**PLANNING APPLICATION W/23/0145 ADDRESS: Woodside Conference Centre,
Glasshouse Lane, Kenilworth**
**PROPOSAL: Demolition of Existing Buildings and Erection of 55 Dwellings and
Associated Works**
Planning Officer: Dan Charles

Following receipt of your comments regarding the demolition of existing buildings and erection of 55 dwellings and associated works at Woodside Conference Centre, Kenilworth, dated 15 August 2023, please find below my responses.

Plan Layout of Attenuation Basin

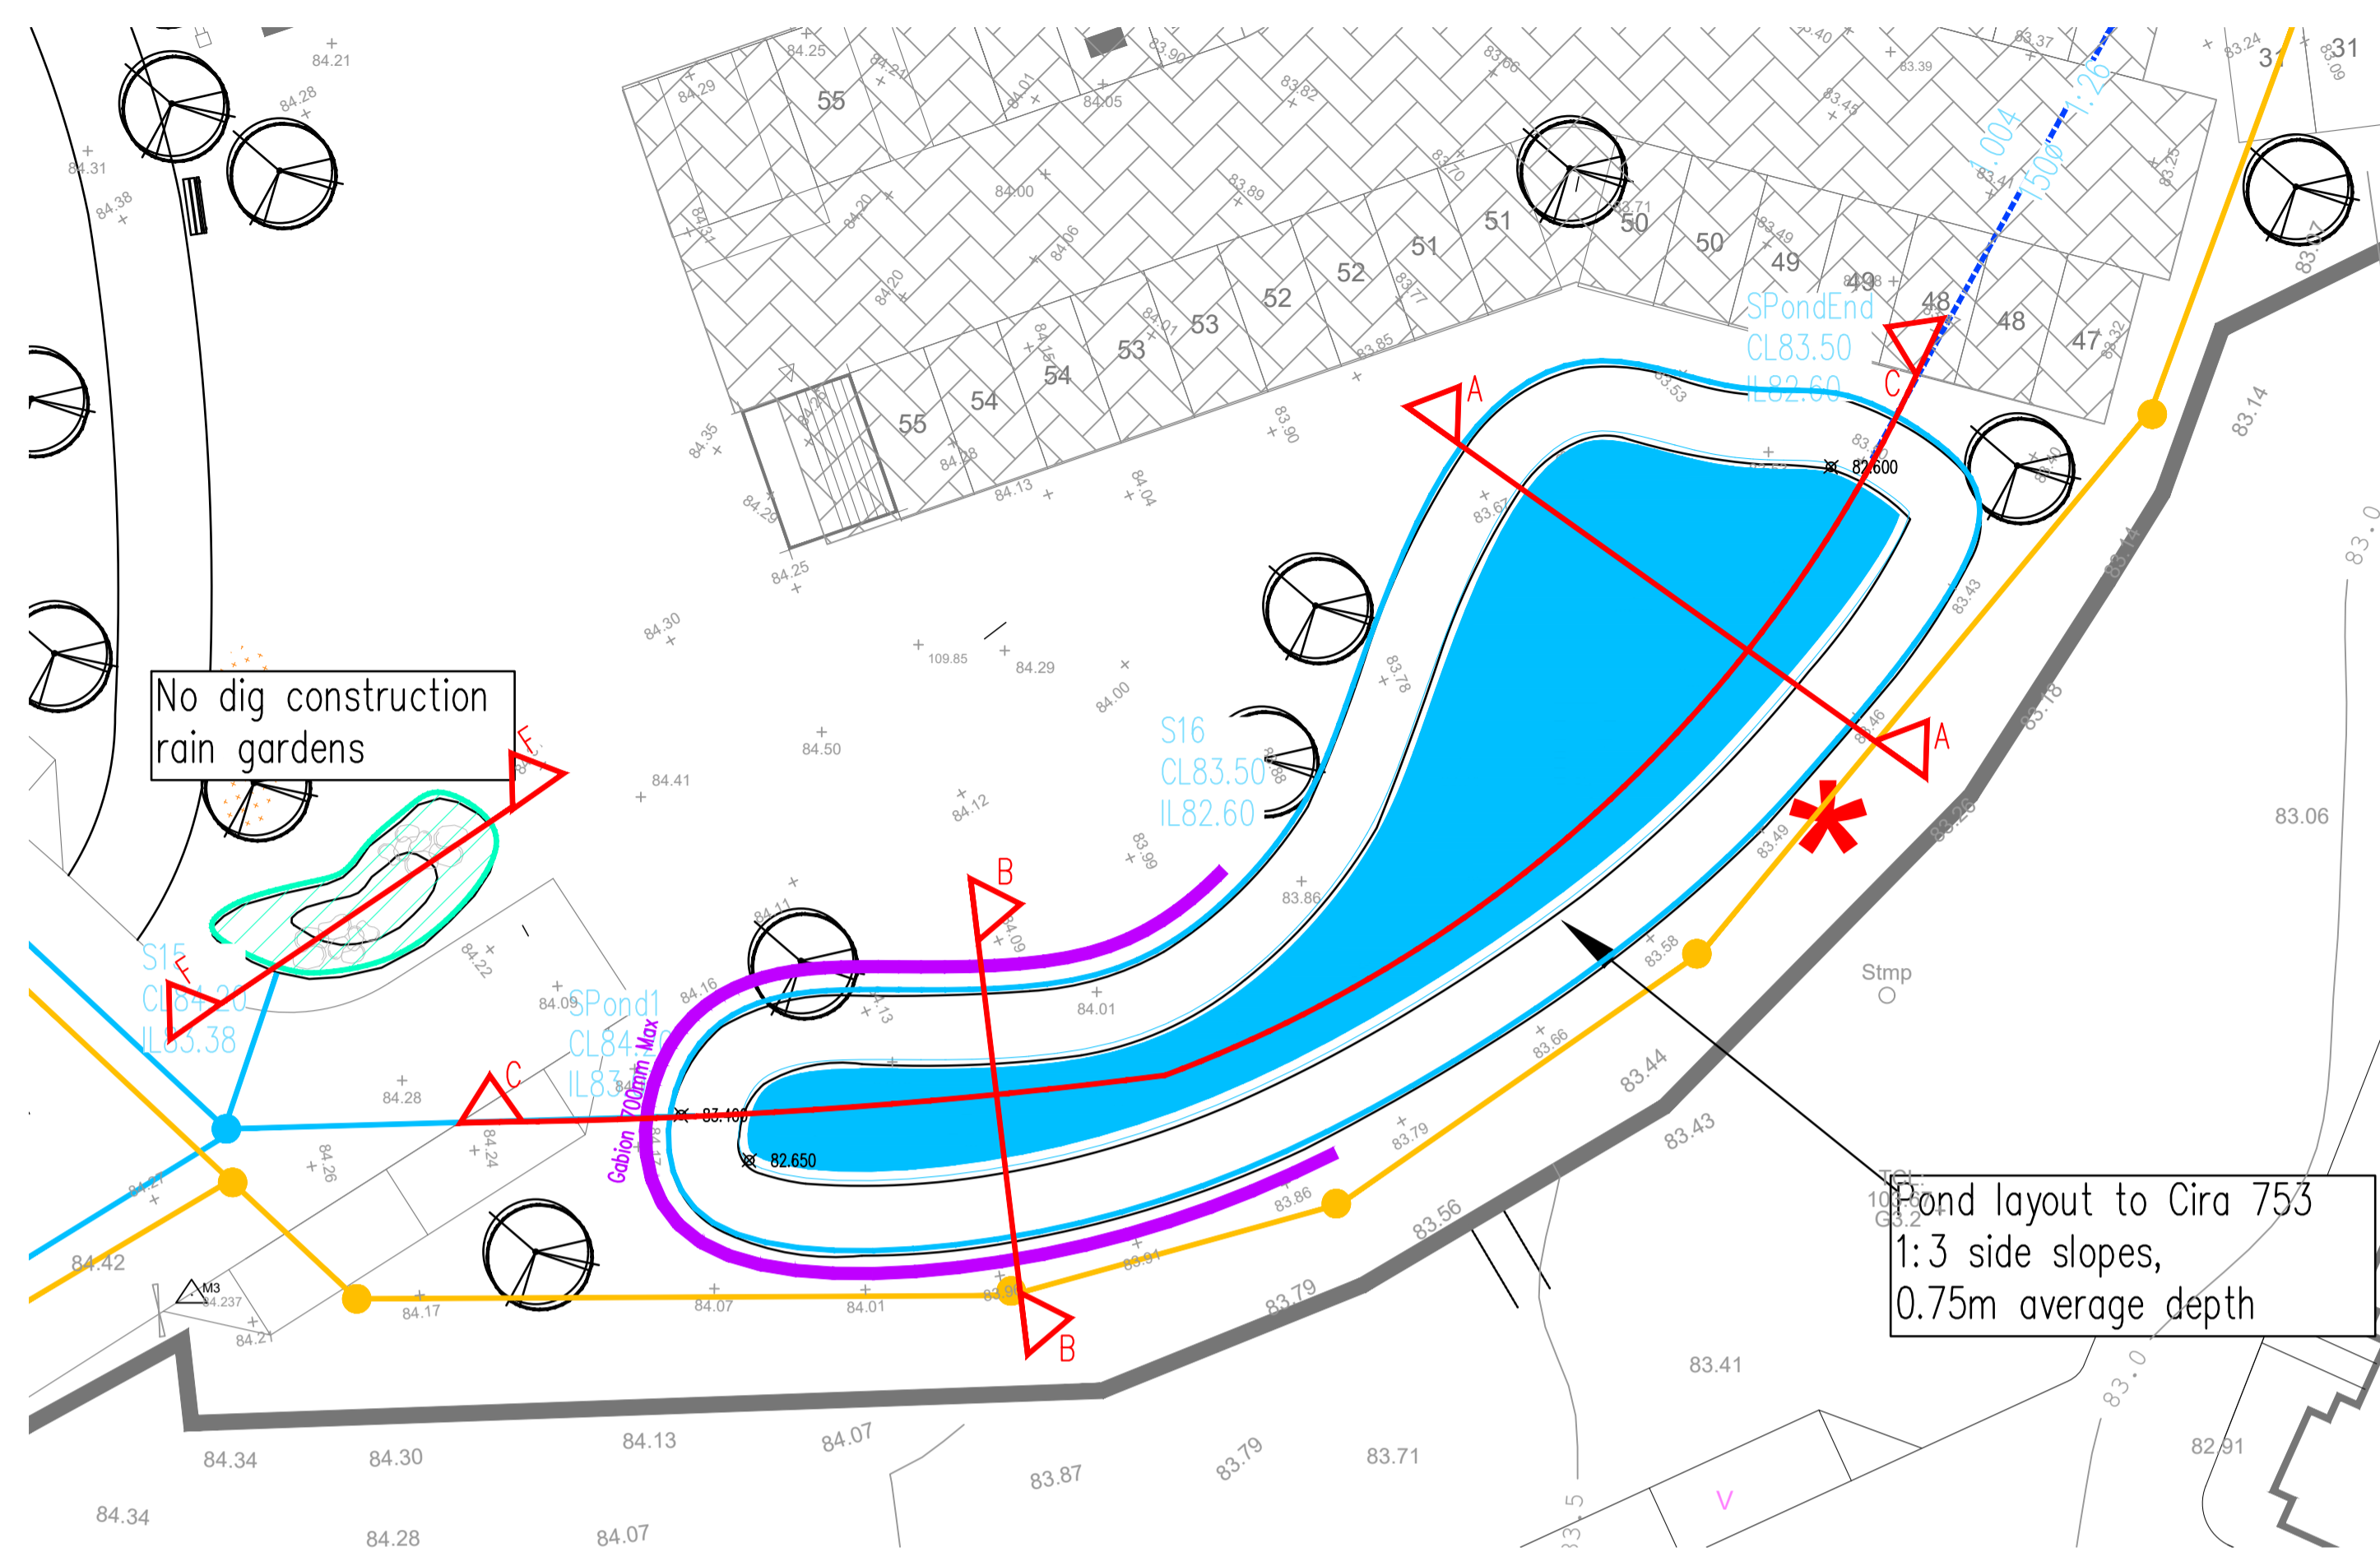
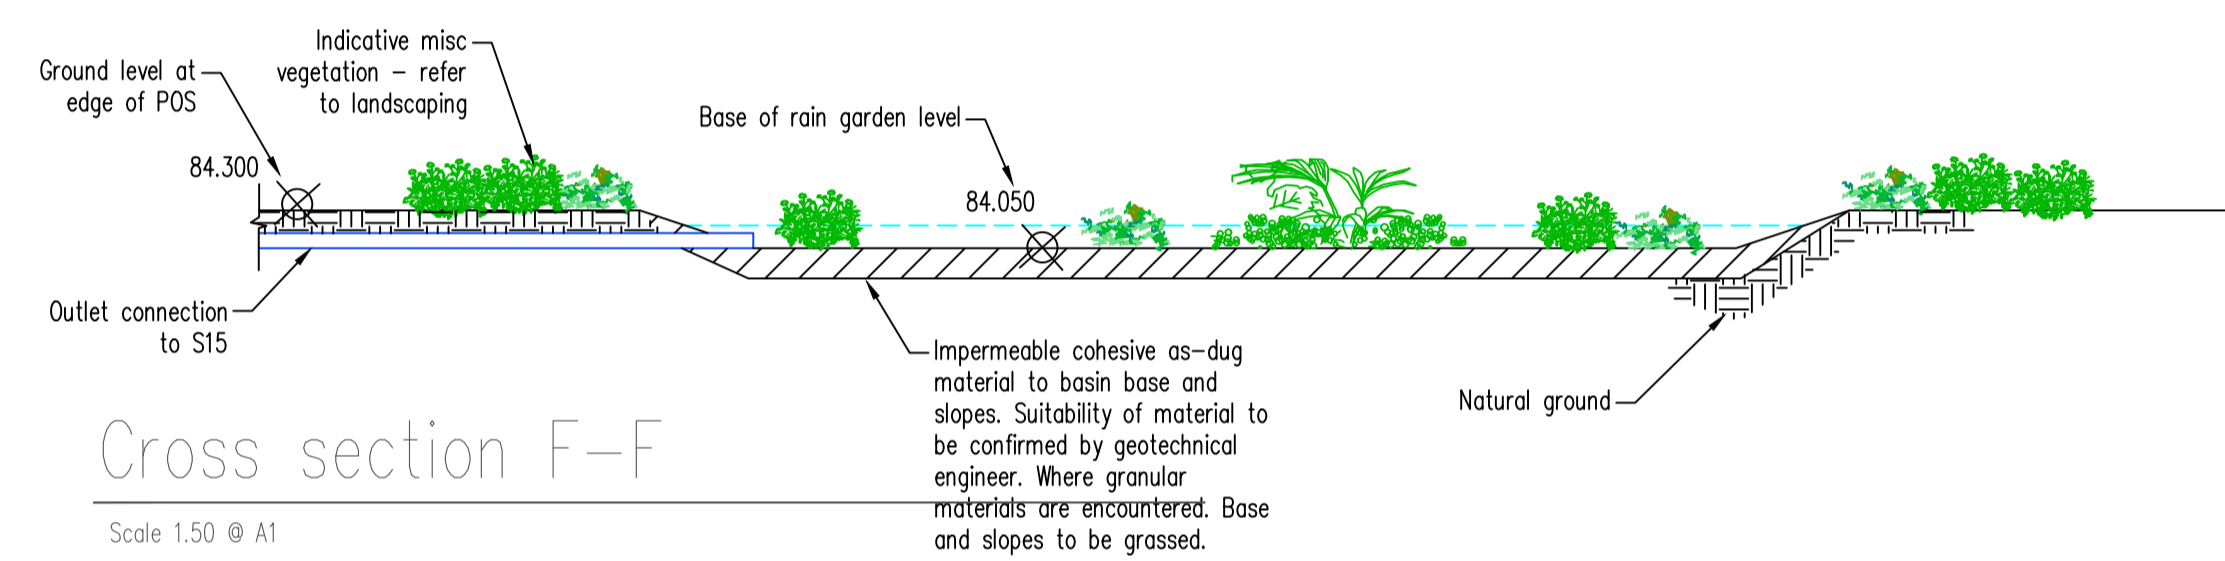
“Whilst EDP mention the basic ecological principle of avoidance (to habitats & species of ecological concern) as being the preferred first step before looking at potential mitigation and compensation measures, However, this option does not appear to have been considered in their Ecological Appraisal. There is a large existing waterbody at the eastern end of the site, currently surrounded by dense bramble dominated scrub. Although EDP checked the waterbody for GCN (not found), they do not mention that these features – which have remained undisturbed for some time, provide a good continuous block of native habitat which will provide valuable shelter, foraging and breeding opportunities for a range of species including hedgehogs, reptiles, amphibians and birds such as wren which nest close to the ground.

The development as proposed suggests replacing this relatively large area of mainly undisturbed habitat with many smaller, scattered features including a much smaller attenuation pond in a different location.”

The reason for the loss of the pond and surrounding scrub is as a result of the topography of the site and the proposed outfall location. An alternative outfall location is not feasible, without a pumping station, due to the topography of the site and the sloping down towards the eastern end of the site. A Geocellular Storage Tank is required as part of the drainage strategy which can only be installed downstream of another tank and the proposed, above ground, source control SuDS features, such as the attenuation basin located centrally within the site. Therefore, the only possible positioning for the tank and outfall, are in the location of the existing pond.

Within the layout proposed by Vistry, a new pond and a seasonally wet SuDS basin will be created within the site, which will have better connectivity to the retained orchard adjacent to the site and to the areas of woodland to the south and west. In addition to this, the existing pond is of poor condition owing to its poor water quality, cover of duckweed, high level of shade and lack of aquatic vegetation. The pond and SuDS basins proposed within the development layout will be managed to maximise them for biodiversity value, which can be further detailed within the LEMP. This document will also ensure the long-term maintenance and management of these features to guarantee that they provide as much value as possible for biodiversity utilising the site.

The area of the proposed pond (346 sqm) is also larger than the area of the existing pond (309 sqm), which when combined with the area of the SuDS basin (221 sqm), almost doubles the provision of aquatic features available for biodiversity within the site (at a total of 567 sqm) as well as providing better quality habitats for the reasons described above.

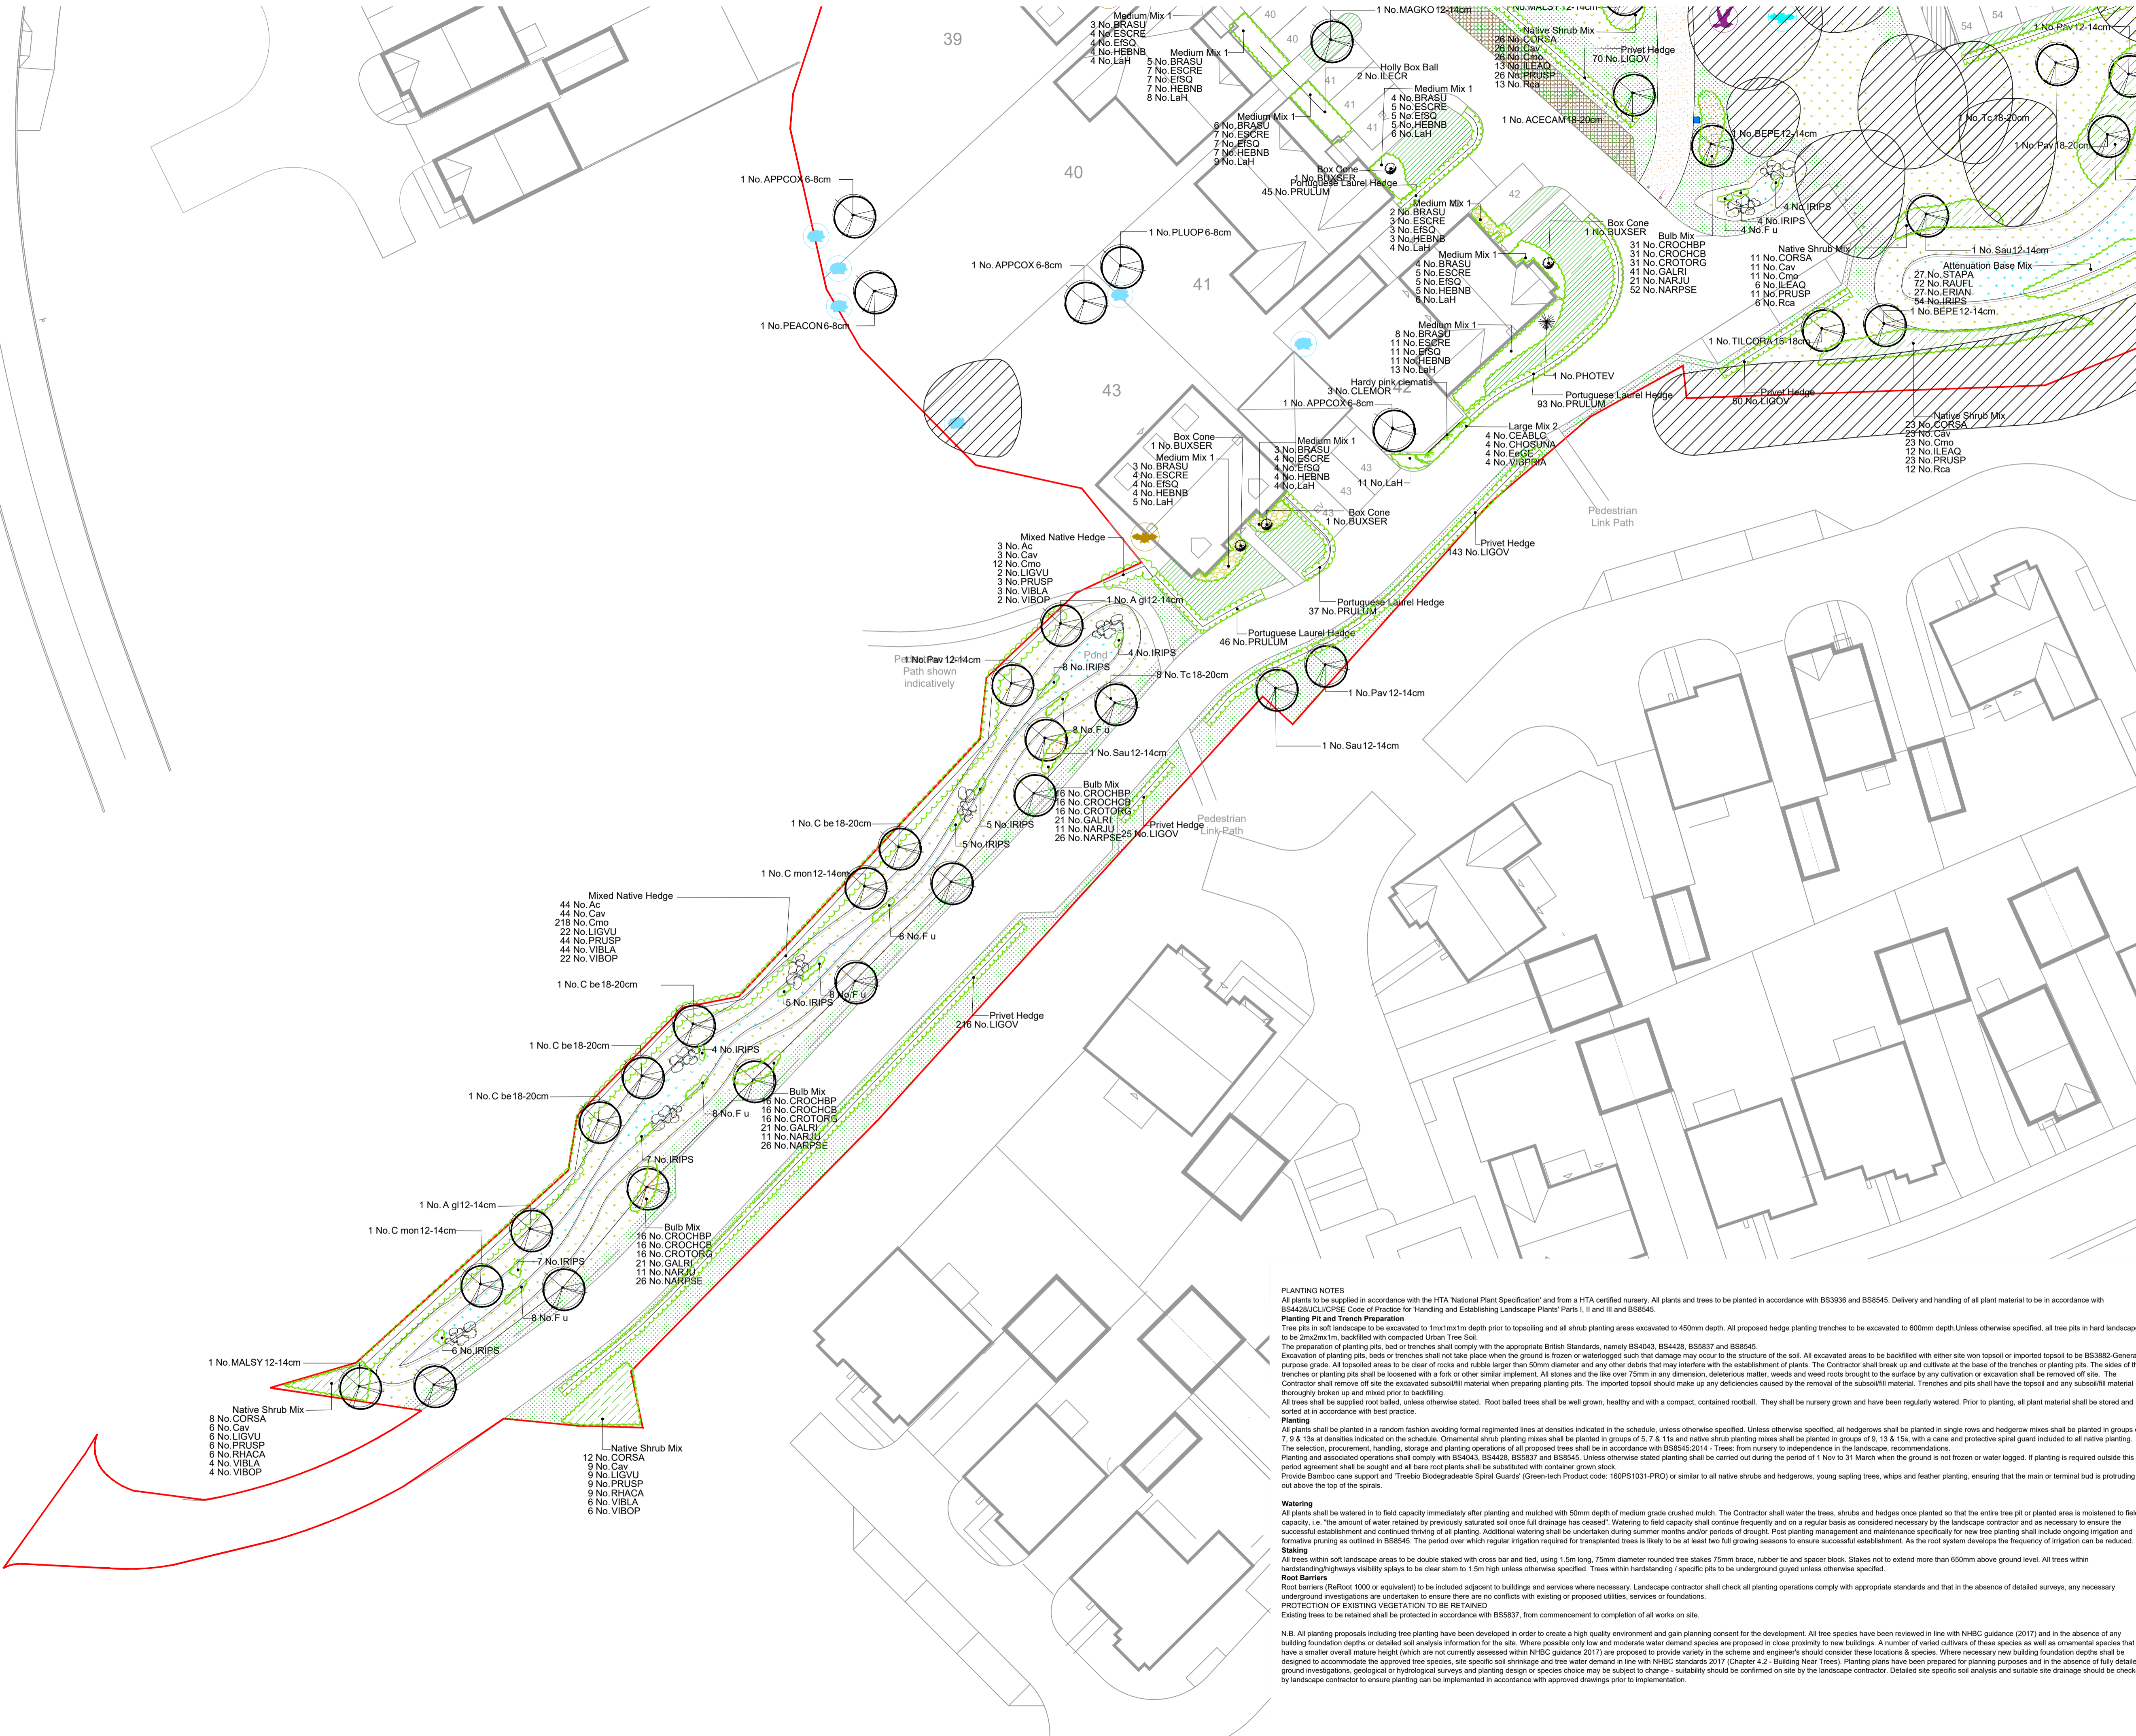
“Even though the surveys found only small numbers of roosting bats in the buildings, the principles of BNG should be followed. The proposed plan appears to show a very small number of bat boxes, and all of these except one are sited on retained trees, with only one proposed for a roof. Whilst

these measures are welcome, they do not offer adequate mitigation or compensation. Bat roosting opportunities in buildings (including the use of bat access tiles), have been shown to be more effective than on trees.

Ideally there should be bat access and nesting bird opportunities provided in at least a third of the proposed houses. Such features are relatively inexpensive and much more easily included at the development phase."

Given the size and type of the bat roost, no boxes are required as compensation, however we are proposing to provide six bat boxes and one ridge tile, as well as four bird boxes. Given the small size of the scheme, this seems to be an appropriate level of provision for these species. However, in order to provide provision of nesting opportunities equal to a third of the number of dwellings, we would be willing to include an additional five bat/bird boxes to total 16 units, some of which can be affixed to dwellings.
